Planning Inspectorate Light Valley Solar Limited
Secretary Of State For Business, Energy And
Industrial Strategy

Our Ref ZG2026/0307/GOV (attn of Linda Drake)
Your Ref EN0110012 Light Valley Solar
Date 11 August 2026

Light Valley Solar
Procedural Deadline 1 – Post Hearing Submissions Action Points

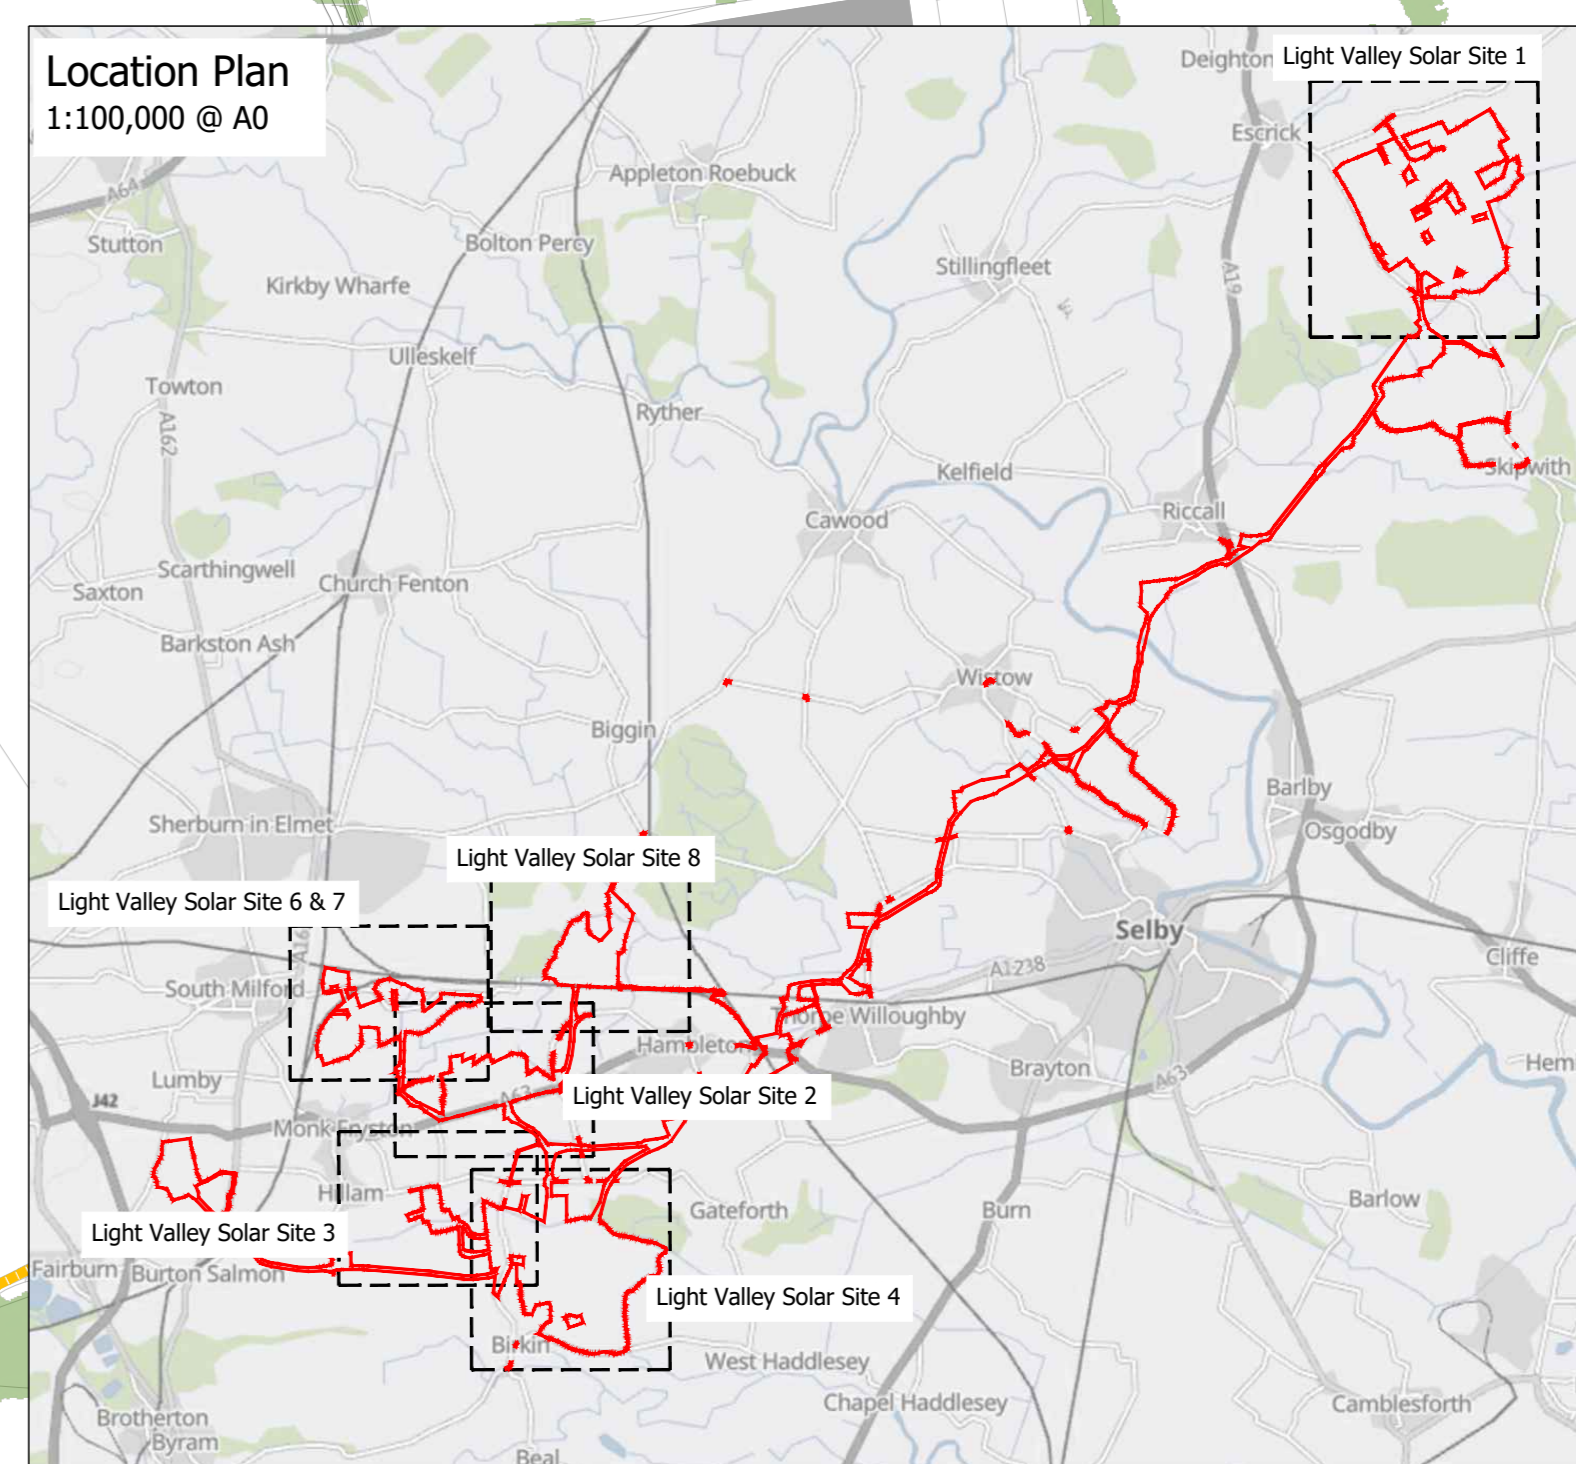
NYC comment – With solar development site 1 (solar panels covering approx. 70ha introducing industrial elements into a strongly rural and tranquil area) the sense of tranquillity would experience the greatest change as a result of the proposed development.

The Outline Environmental Masterplan – Site 1 – sets out opportunities for addressing adverse effects through mitigation. The masterplan can be refined during the detailed design stage.

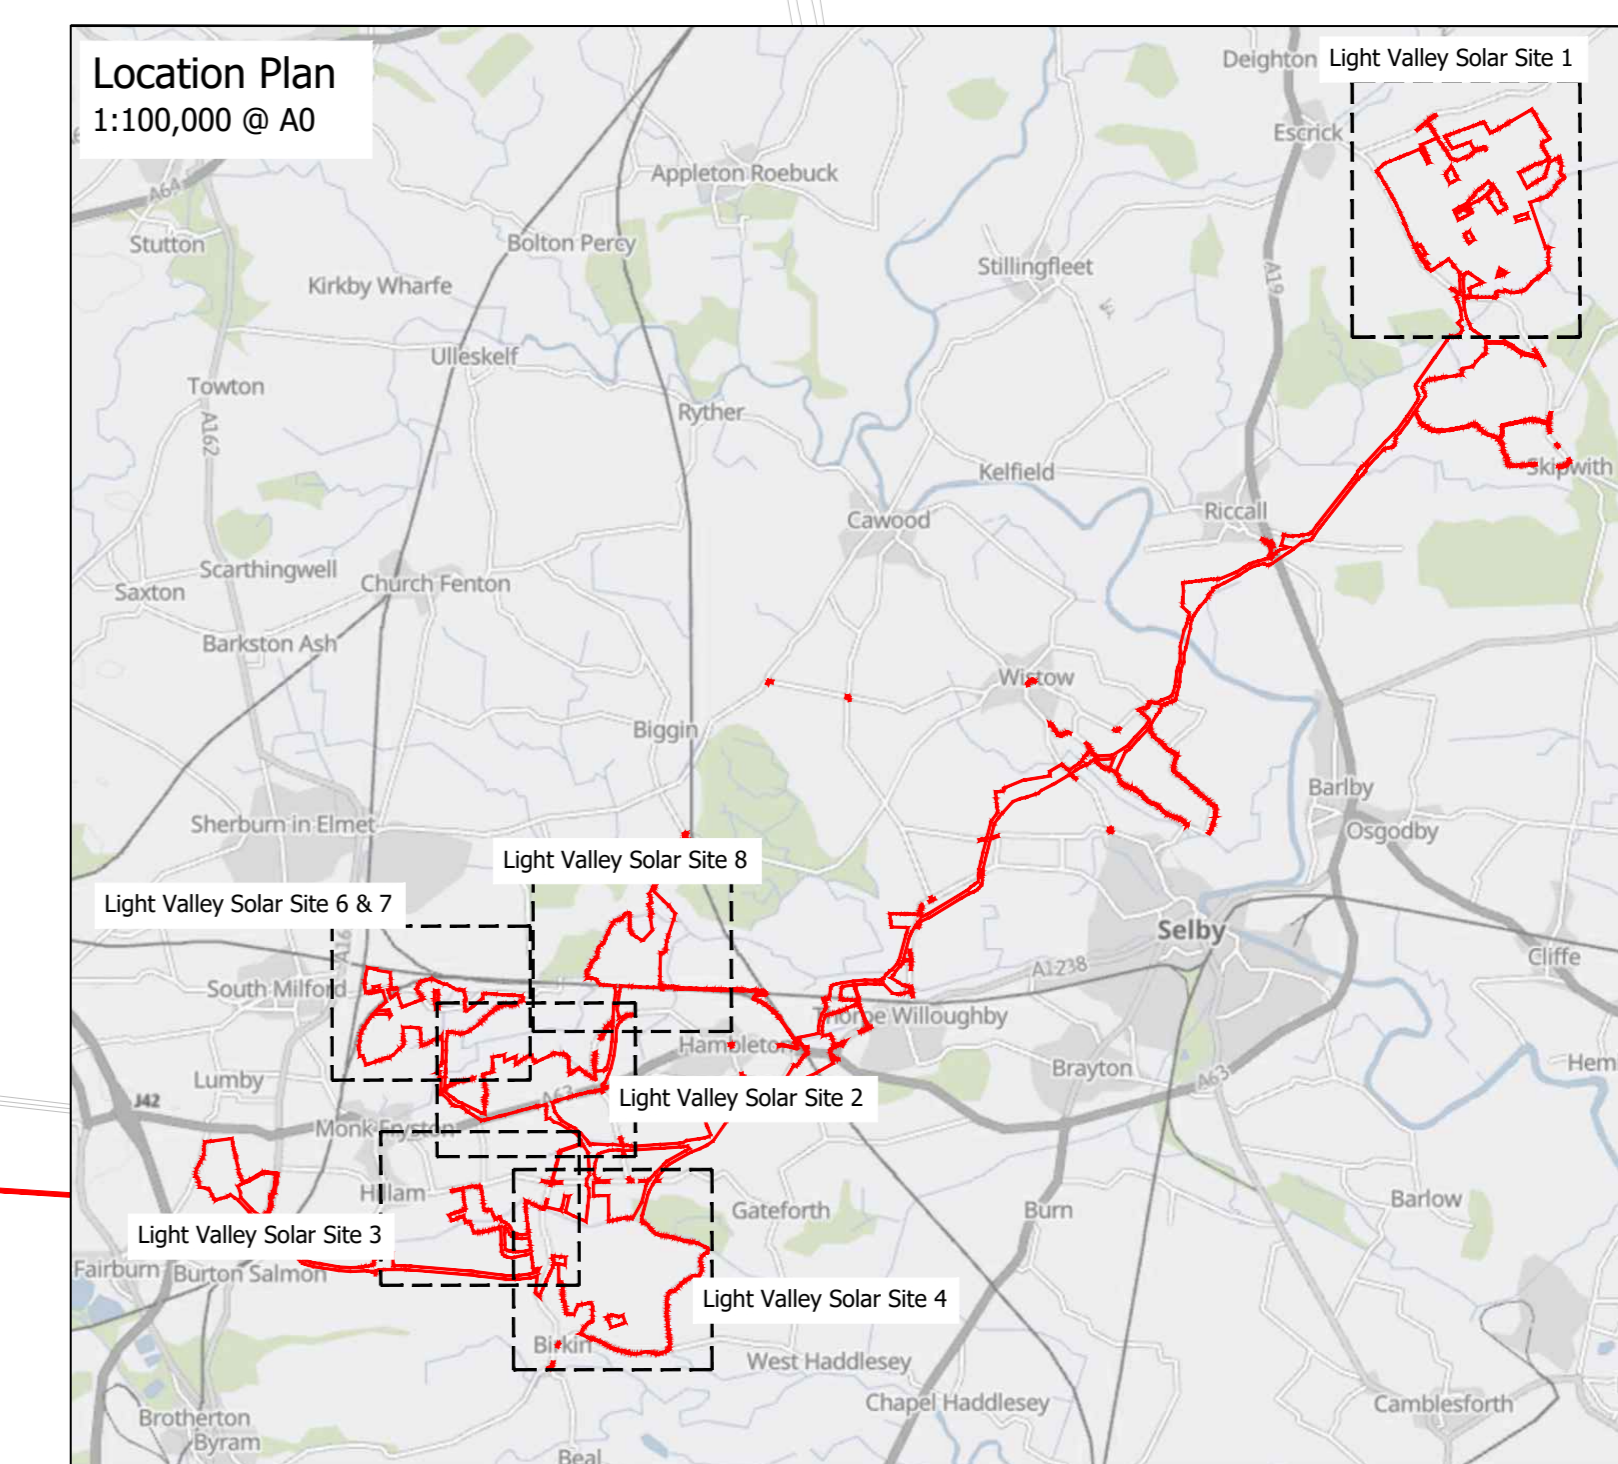
NYC comment - site 2 with larger proposed infrastructure (in terms of scale massing) in the form of the sub station and battery energy storage site (BESS) will impact on the physical character of LCA 11 as *‘the area may be highly sensitive to relatively small changes in the landscape, due to the*

very flat, unenclosed nature of the landscape which enables new features of all scales to be highly visible. This is particularly the case, as the substation and BESS have a combined frontage of 700m onto the A63, with a limited set back from the road.

Mitigation planting is proposed but it will depend on successful establishment and may take a number of years to appropriately screen or filter views towards the sub station (reaching a height of 13 metres) and the acoustic screen to the perimeter of the BESS reaching a height of 5 metres.

In its Local Impact Report, North Yorkshire Council, have raised concerns about the adequacy of the applicant's assessment of Site 2 and the siting of the infrastructure (sub station and BESS). The Council has requested that the assessment of the substation and BESS requires further investigation during the Examination in terms of effects on landscape and views, embedded mitigation and mitigation proposals.
